REVISION RESPONSE LETTER

**RE: Claremont Business Park 2 Filing 1, Lot 7
Site Development Plan
File Number PPR2030**

DATE: December 3, 2020

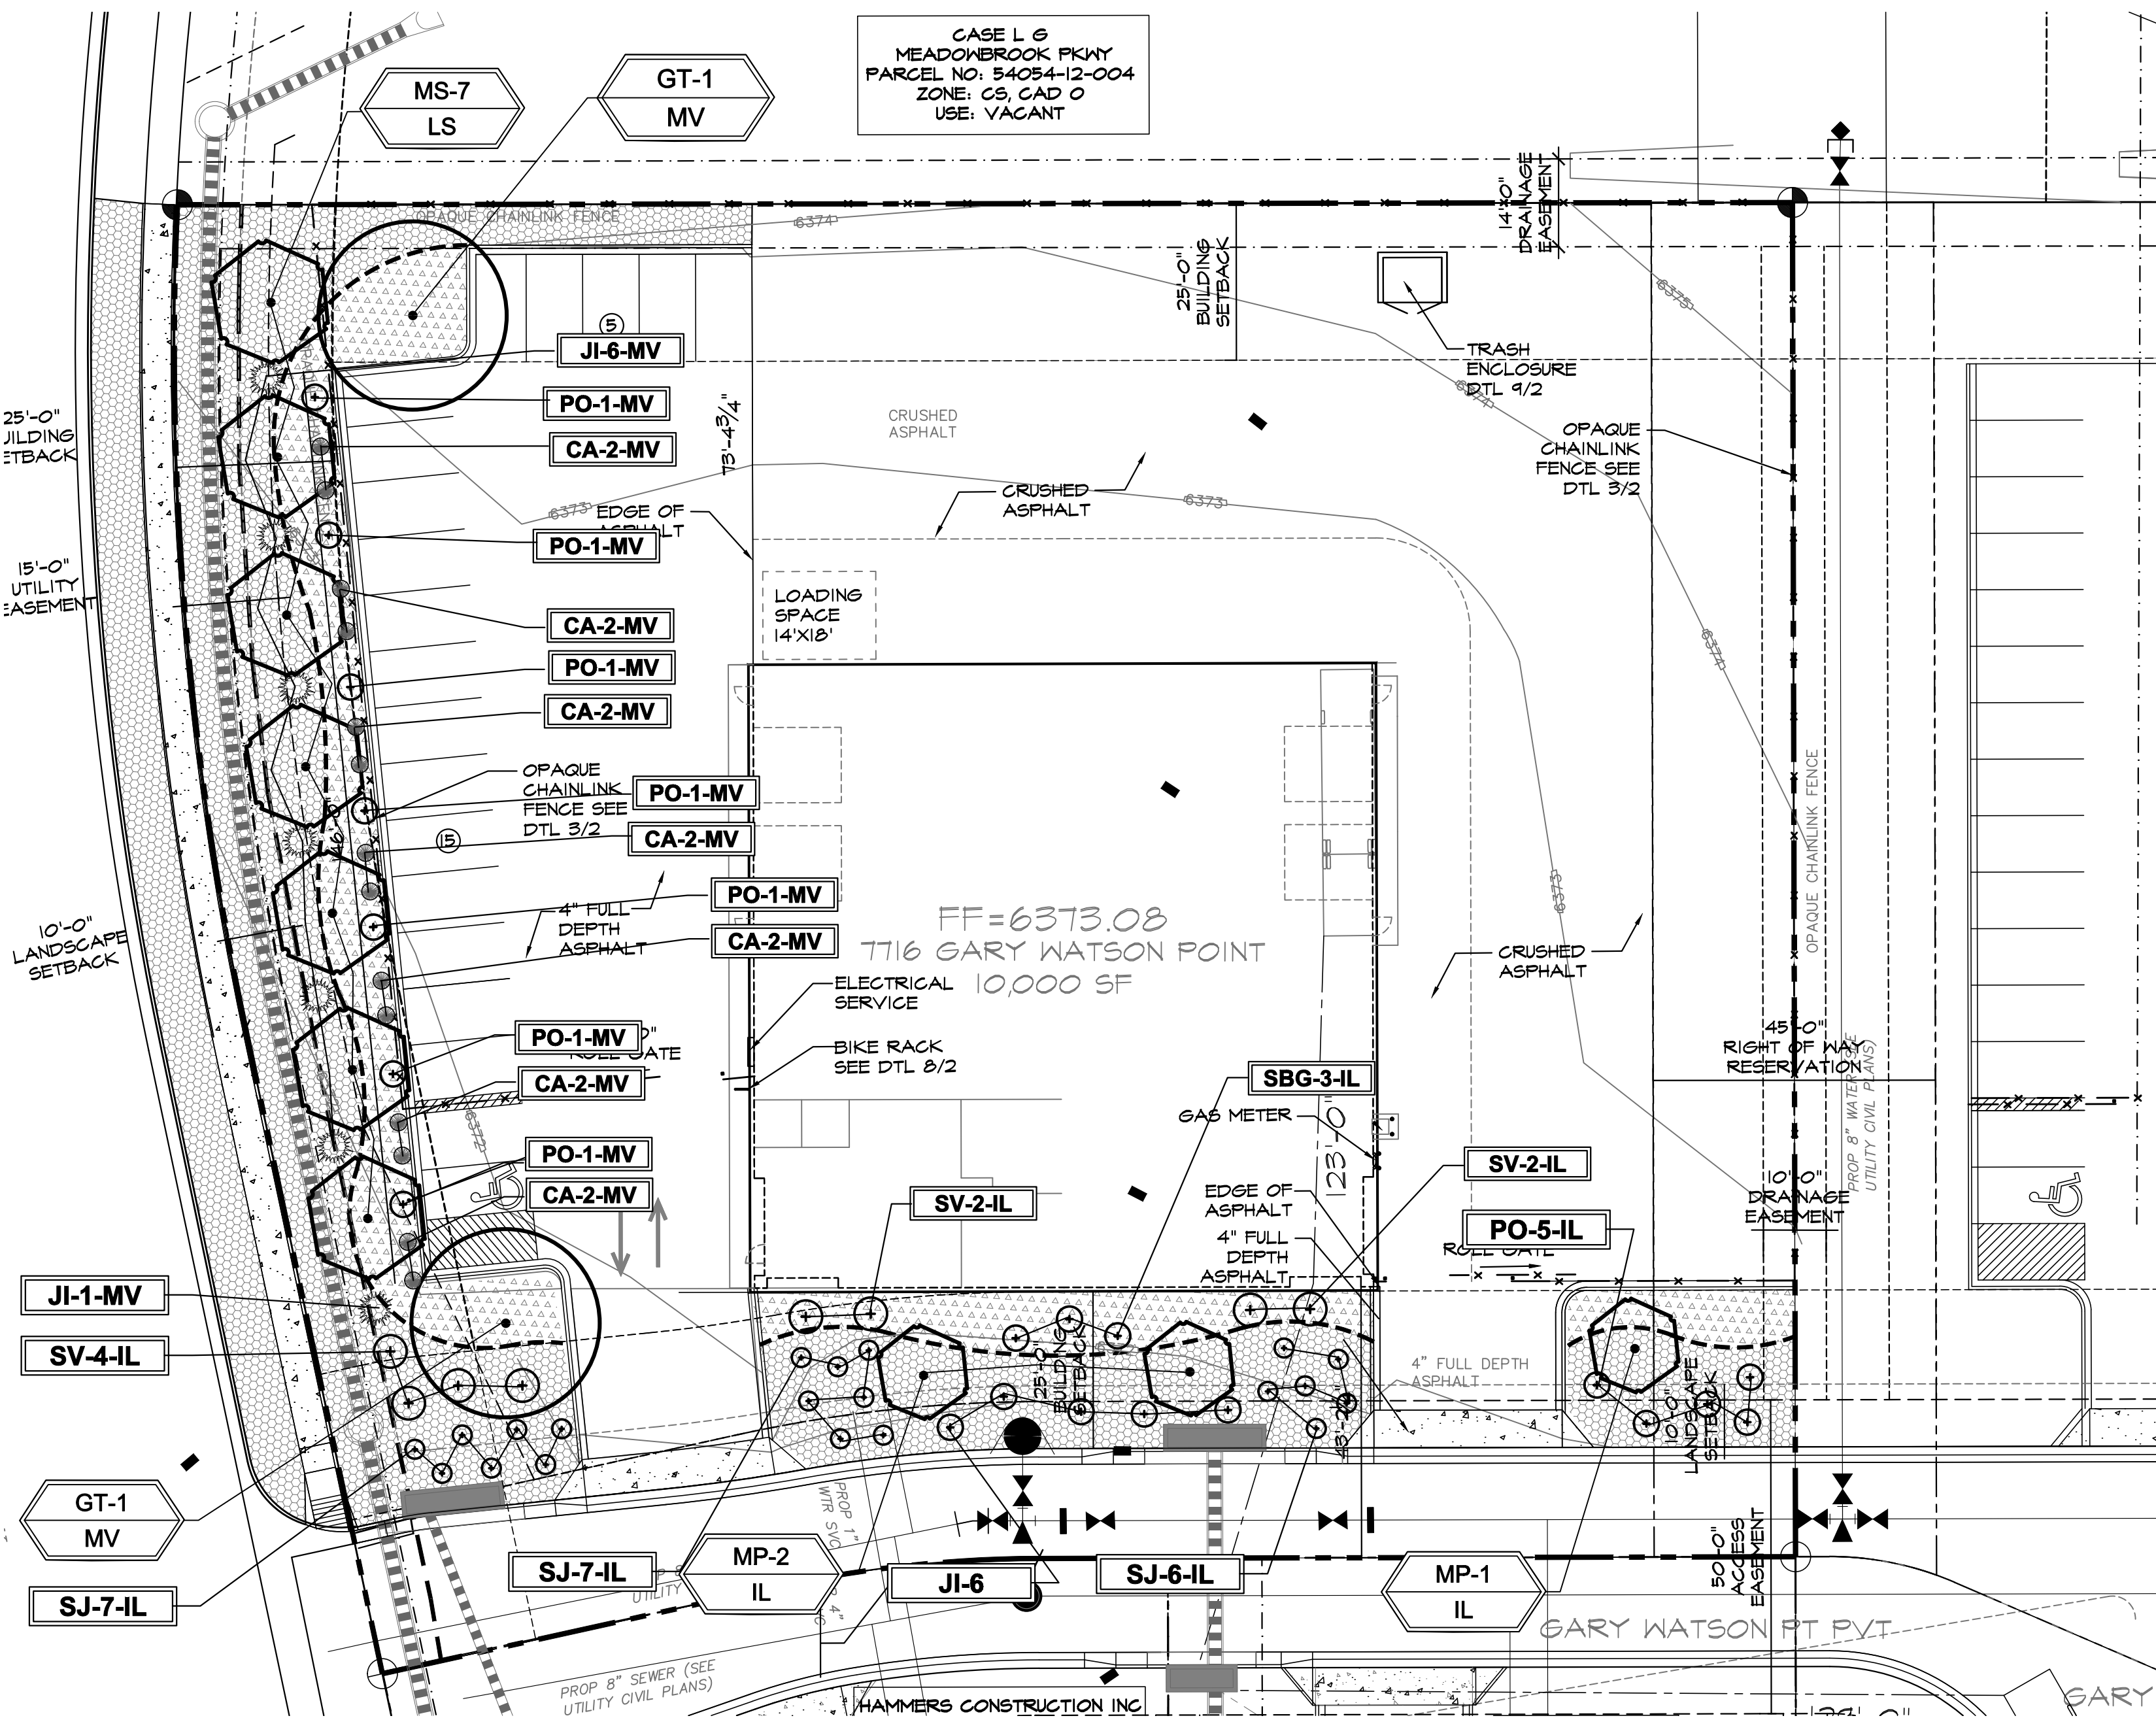
4. *Access Aisle must be located on passenger side of parking spaces. Revise with access aisle on passenger side. Per ICC a117.1-2009, 502.4.1: "Access aisles shall adjoin an accessible route. Two parking spaces shall be permitted to share a common access aisle. Access aisles shall not overlap with the vehicular way. Parking spaces shall be permitted to have access aisles placed on either side of the car or van parking space. Van parking spaces that are angled shall have access aisles located on the passenger side of the parking space." Our parking is not angled, so our design is good as shown. No changes made from this comment.*

5. *FYI per ADA criteria, sidewalks should go around drive apron. **Sidewalks updated.***
